**SHOALHAVEN CITY COUNCIL – MAJOR PROJECT 06_0228 – MR293, SHOALHAVEN
STARCHES ETHANOL EXPANSION PROJECT - MOD 3**

Reference is made to your letter dated 28 June 2012 regarding the subject development project forwarded to Roads and Maritime Services (RMS) for consideration.

PLAN SHOWING PROPOSED TRAFFIC ARRANGEMENTS  
REDUCTION RATION 1:500

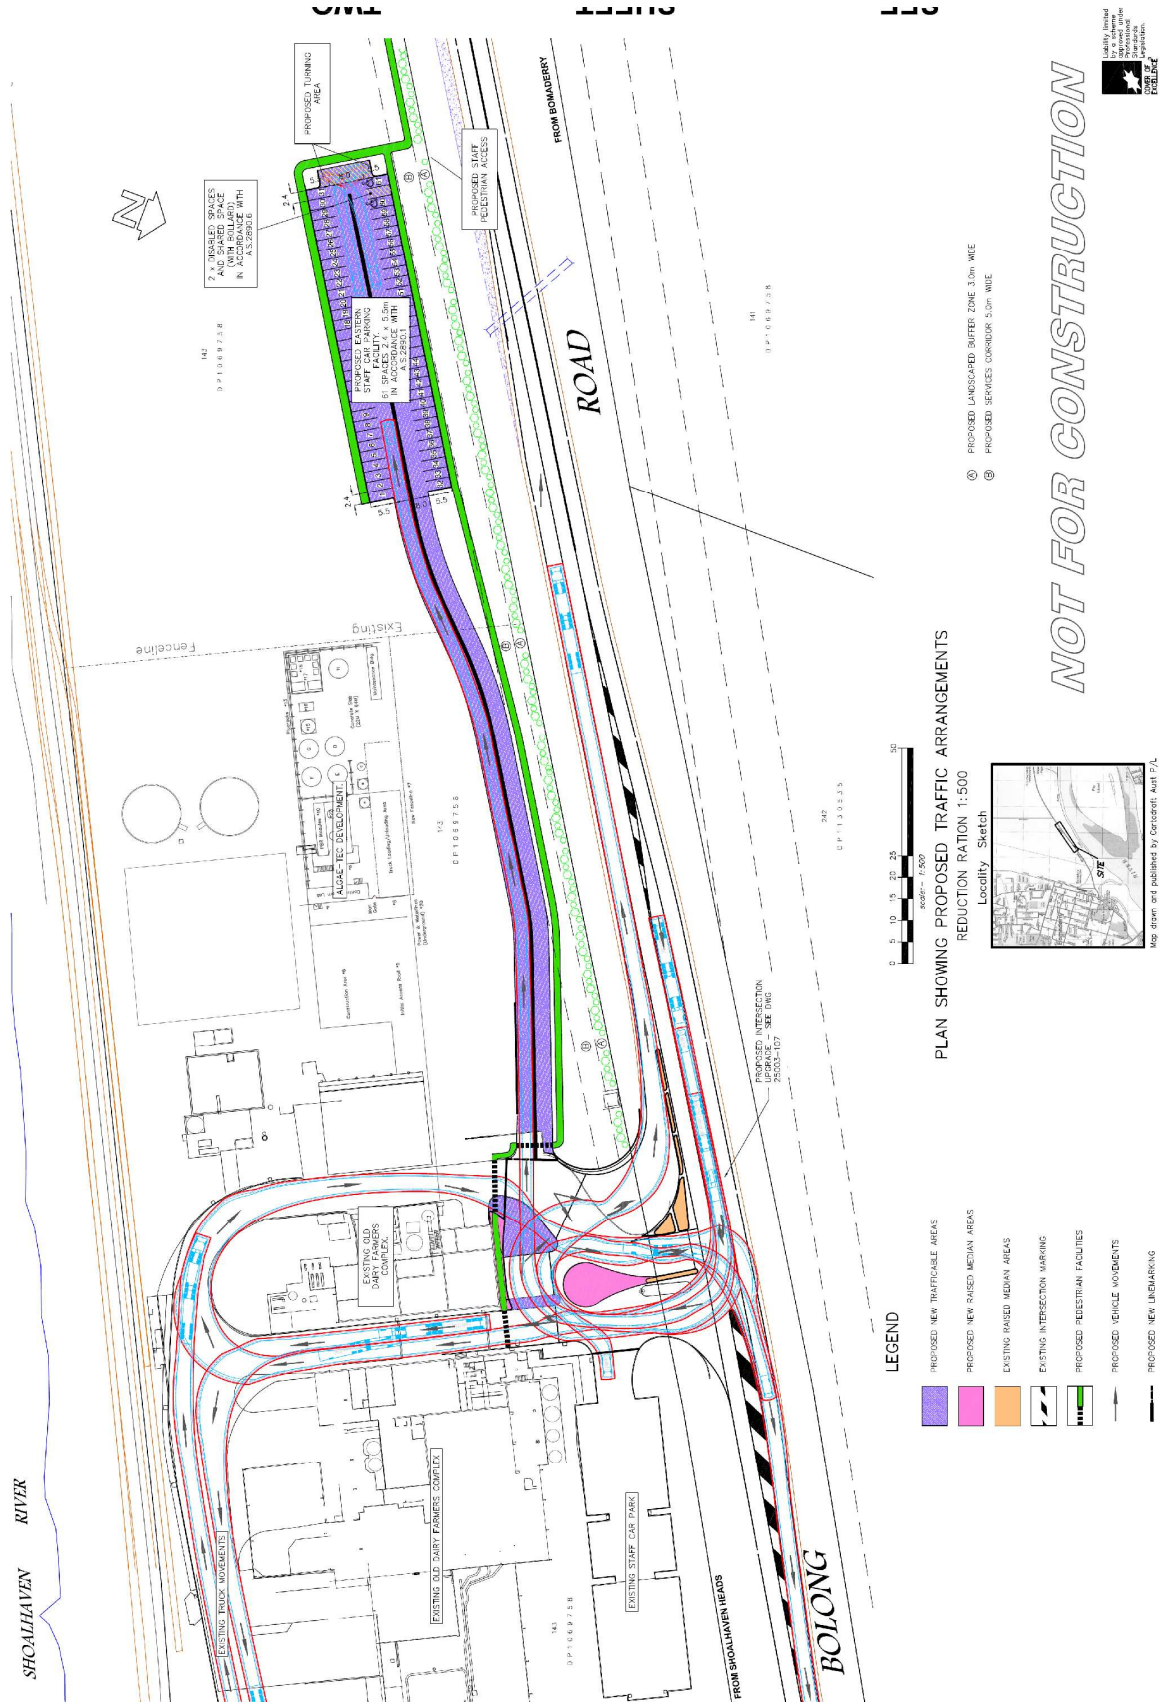
- Prior to any occupation, the developer shall upgrade the junction of Bolong Road and Lot 143 DP1069758 to be a sealed Type Rural Auxiliary Left turn (AUL) and a Type Rural Channelised right turn (CHR) configuration in accordance with Austroads *Guide to Road Design – Part 4a: Unsignalised and Signalised Intersections*. The design of the junction shall be based on an 80km/hour design speed. The access shall be sealed a minimum distance of 10m back from the edge of seal.

- A footpath should be provided linking the new car park with the existing footpath network within the Shoalhaven Starches site.
- All roadworks, traffic control facilities and other works associated with this development, including any modifications required to meet RMS standards, will be at no cost to RMS. All works shall be completed prior to occupation.
